From: Martyn White
Sent: 28 August 2020 16:52
To: Planning.Responses
Subject: AL/49/20/PL

Byfields & Nightingale Cottage Nyton Road Westergate PO20 3US

Demolition of 2 No existing dwellings & erection of 7 No. dwellings with associated parking, bin store, alterations to the existing access & extension of the existing footway.

Dwellings 1 & 2

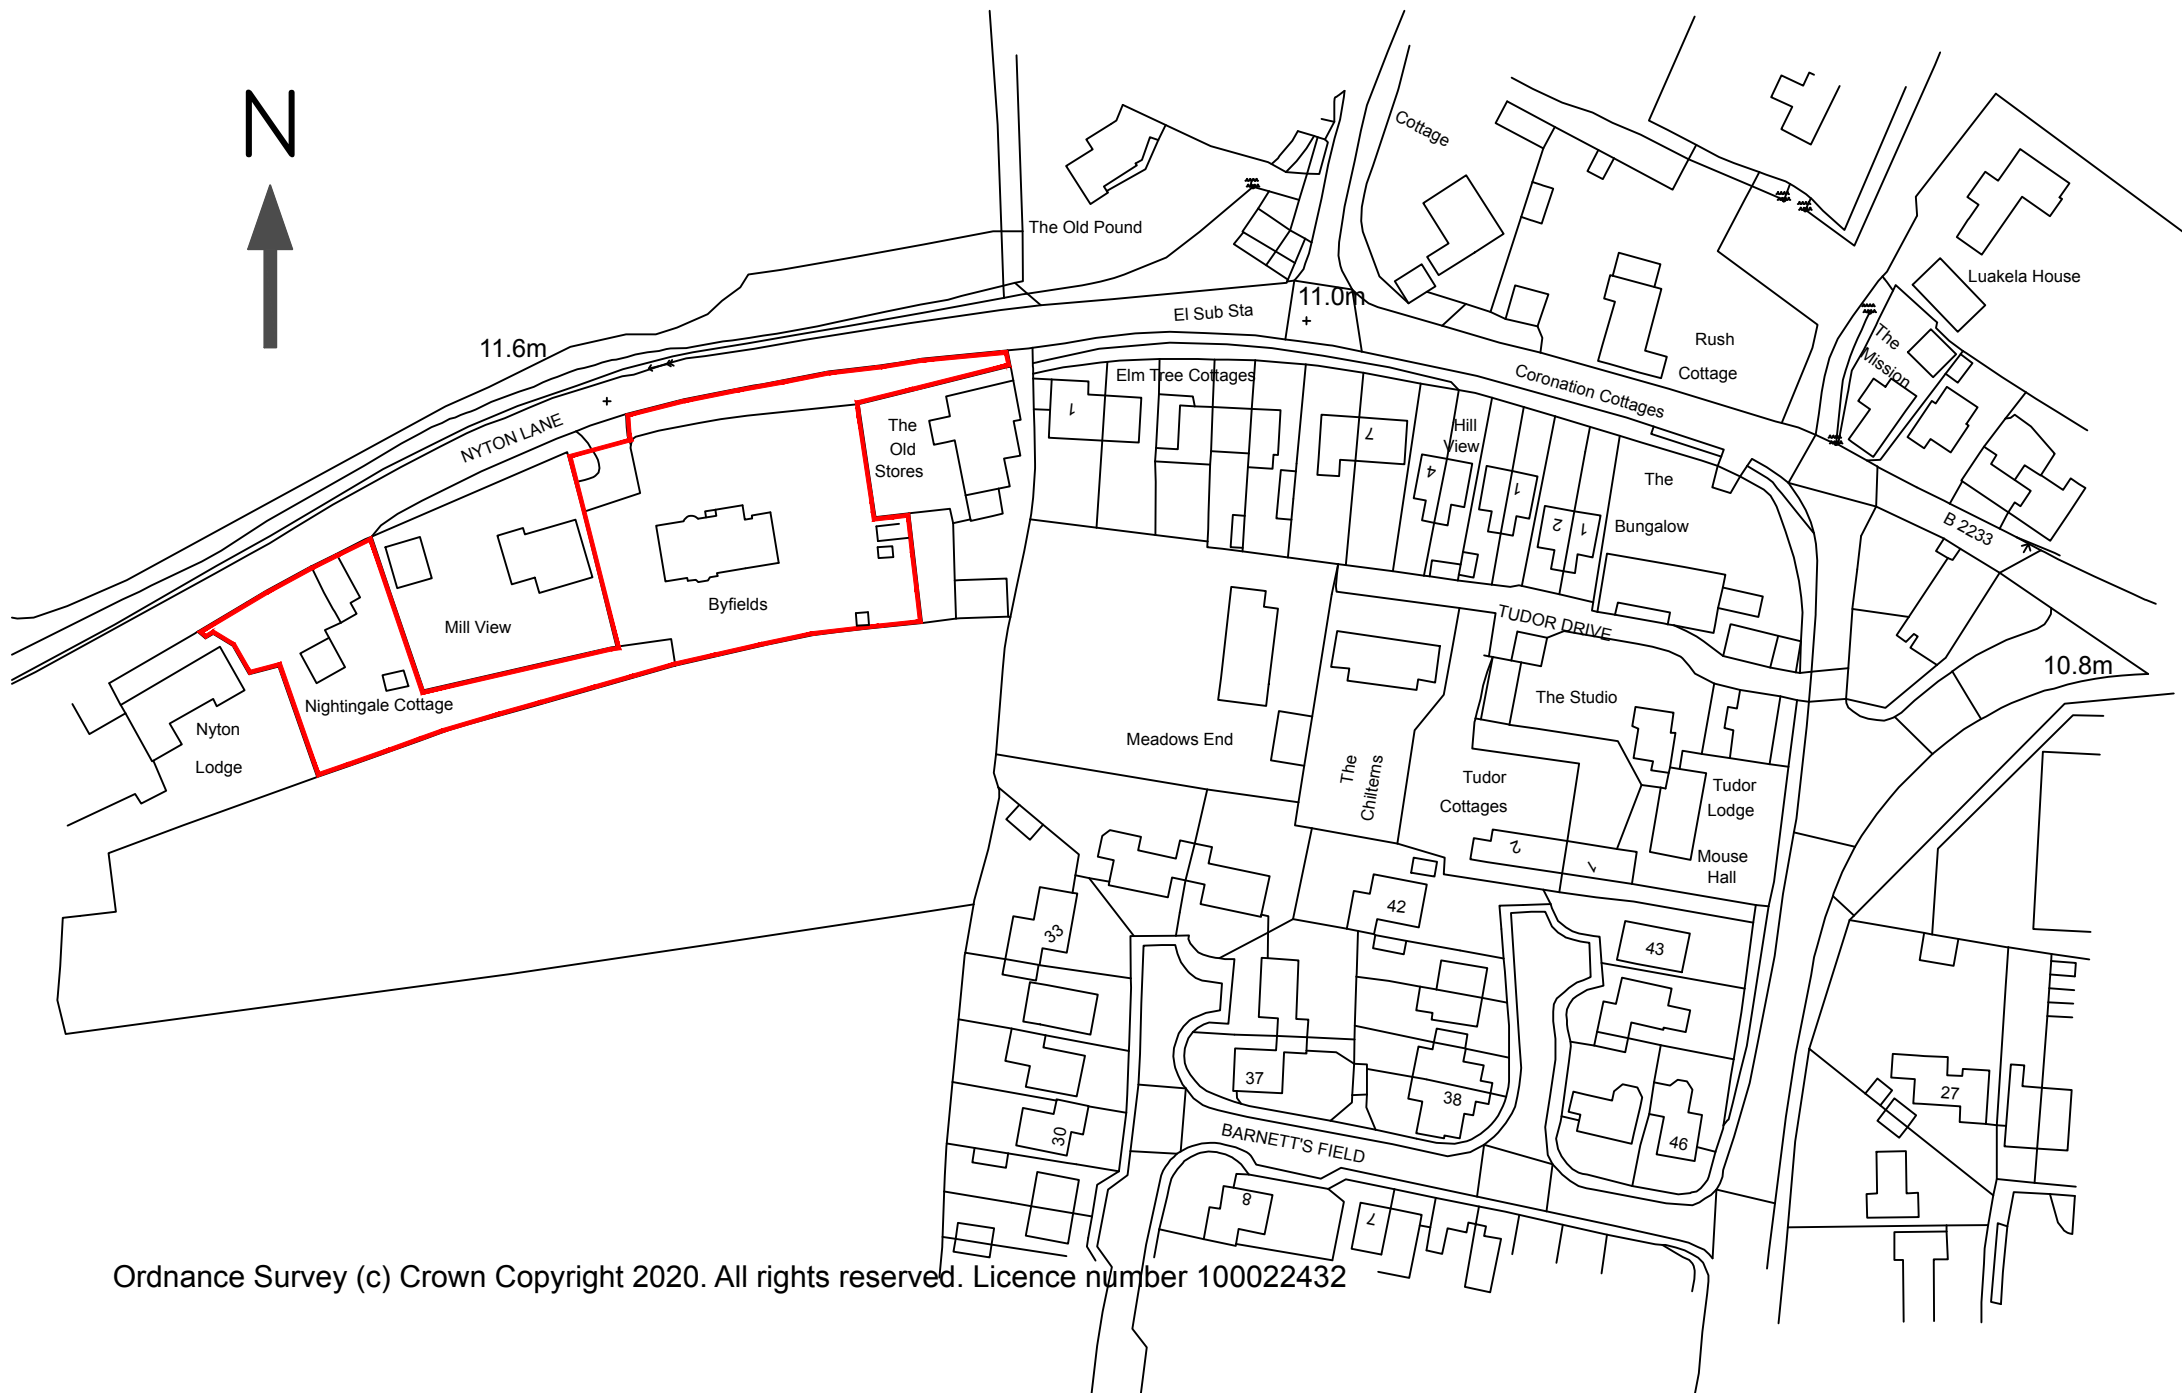
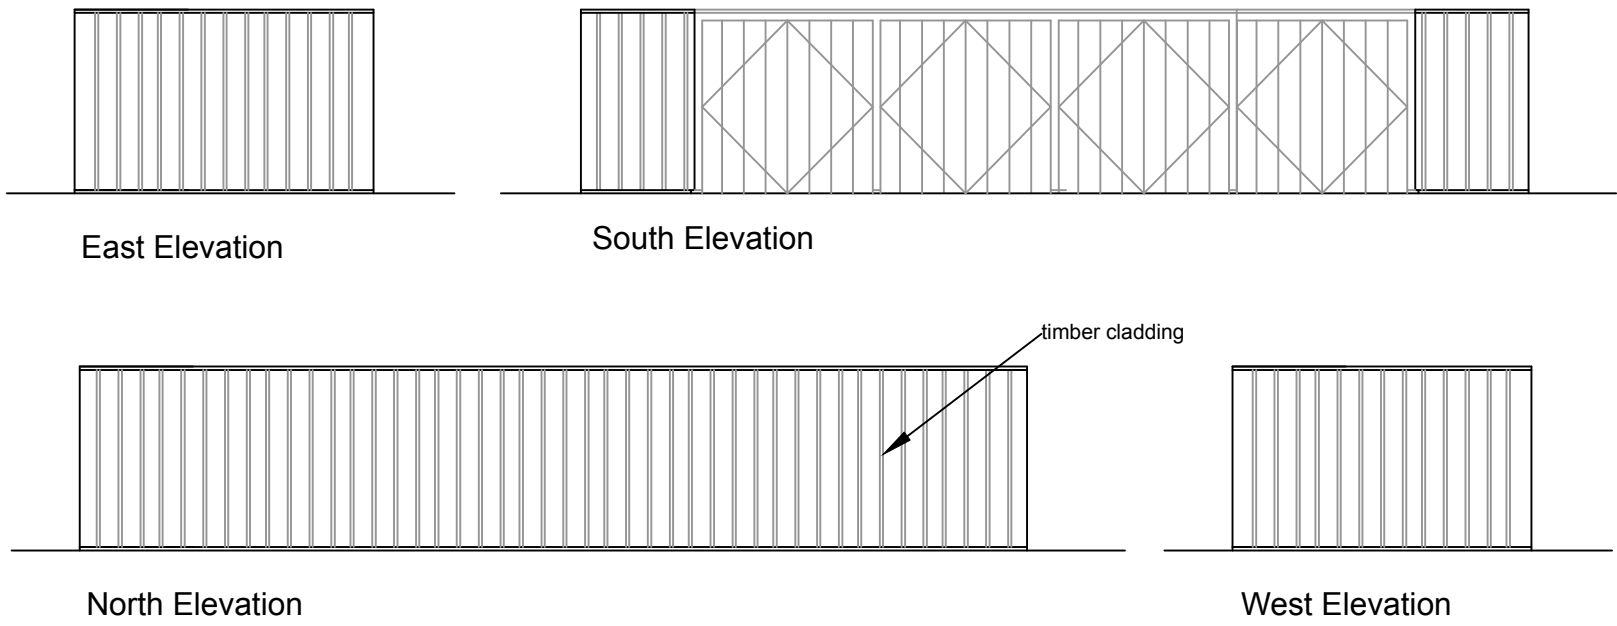
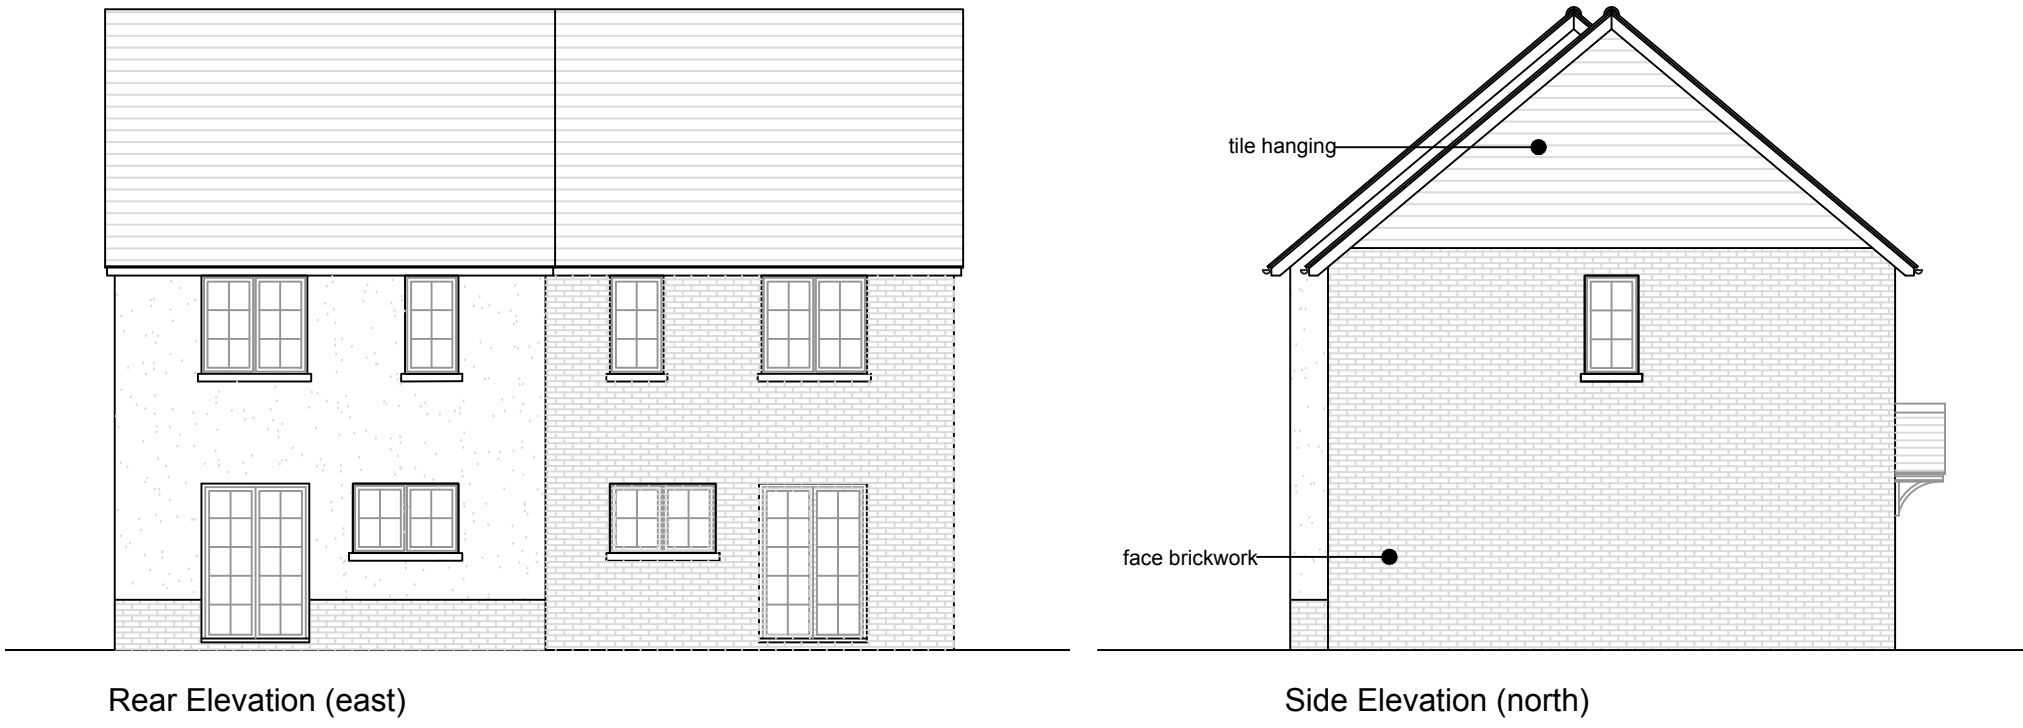
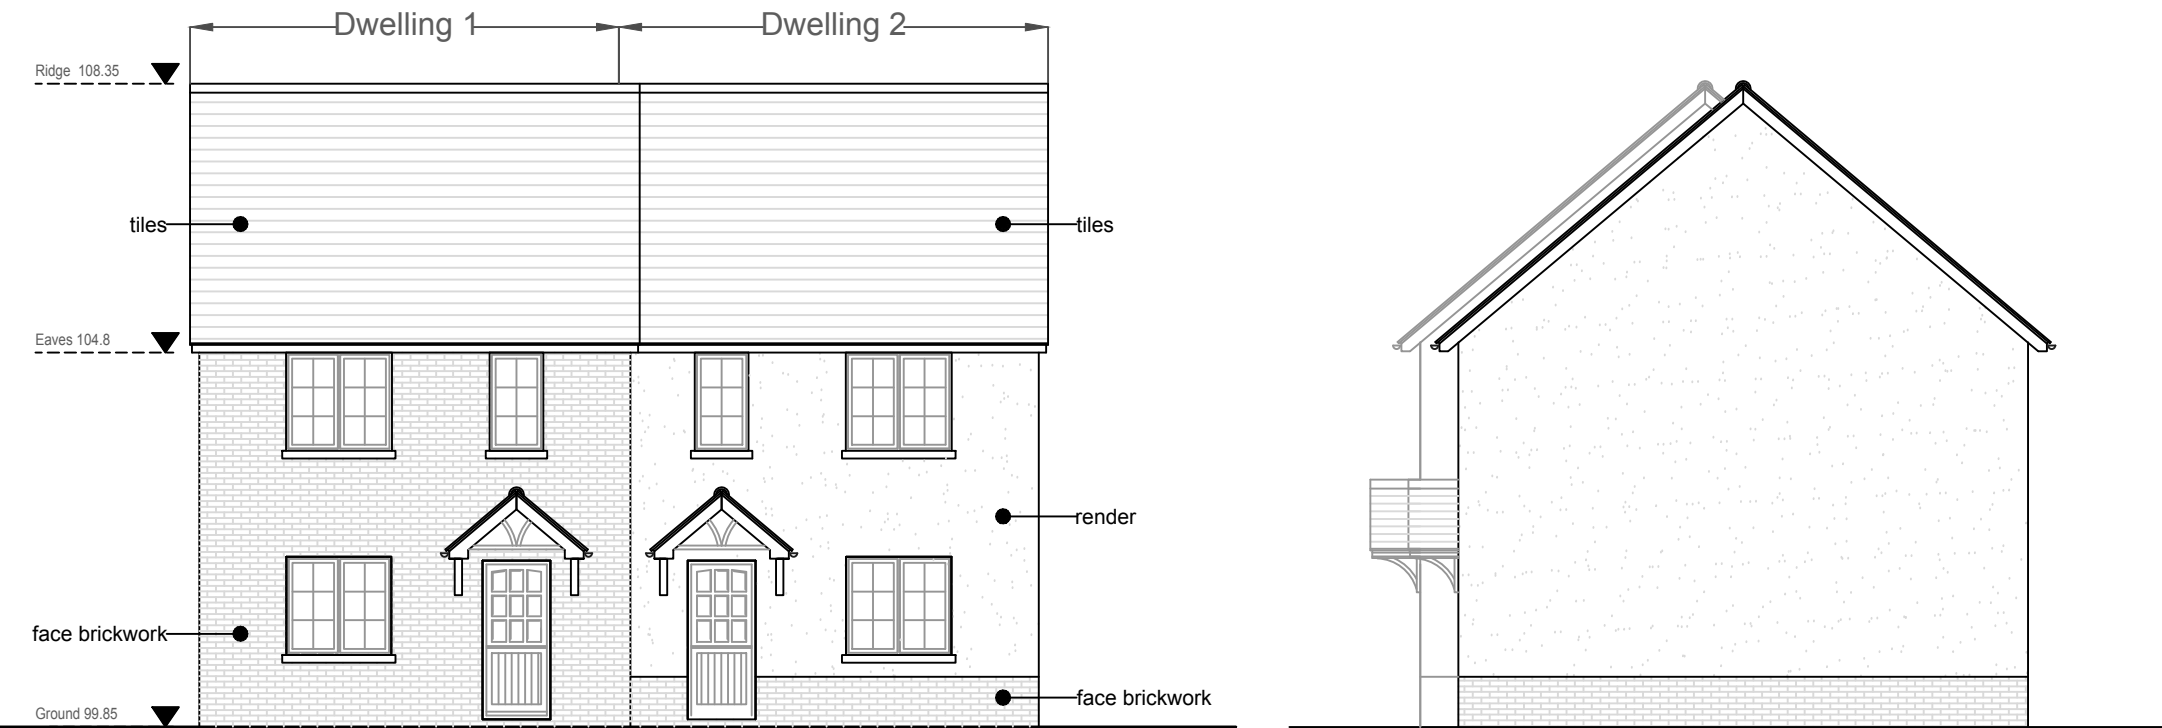
The proposed houses on the Byfield element of the development would appear to be informed by other properties in the locality. Such an idea is a positive one as it would enable it to sit more comfortably in the local area. However, at present, I am of the opinion that some of the details are missing, which will mean that there is the potential for them to appear more as a standard design. I am thinking of the porch detail, window detailing, materials on the front elevation and chimneys which are all seen on the photographs of the two local properties provided as part of the application. All of these small details help to form a more pleasant building, and to fit in with the surroundings.

Whilst there are some positive features of the proposals such as the attempt to replicate other properties in the area, the development is still not capable of support from a heritage perspective due to the lack of detail and the loss of the existing and attractive cottage and flint walling.
